City of Albuquerque

October 6, 1999

RE: CONCEPTUAL G & D PLAN FOR MCDONALD'S/GAS STATION (J-14/D109)
RECEIVED AUG 10, 1999 FOR SITE DEVELOPMENT PLAN
ENGINEER'S STAMP DATED 7-29-99

McDonald's Martineztown Site  
CONCEPTUAL GRADING AND DRAINAGE PLAN

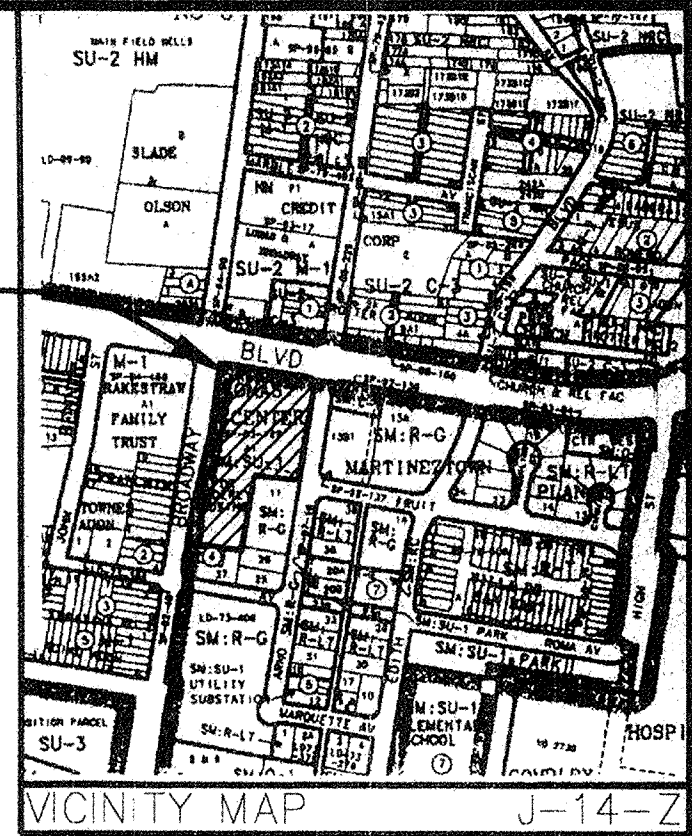
The lettering for the existing & proposed spot elevations are too small. All lettering must be at least 0.10" tall per DPM. Are curb elevations T.C. or F.L.? Show storm drains in Lomas, Broadway and Arno. Include a copy of the Infrastructure List in the next submittal. What is the DRB #?

Do any off-site flows enter this site? It appears that Building C-1 encroaches on the 50' surface drainage easement. Are you vacating this easement?
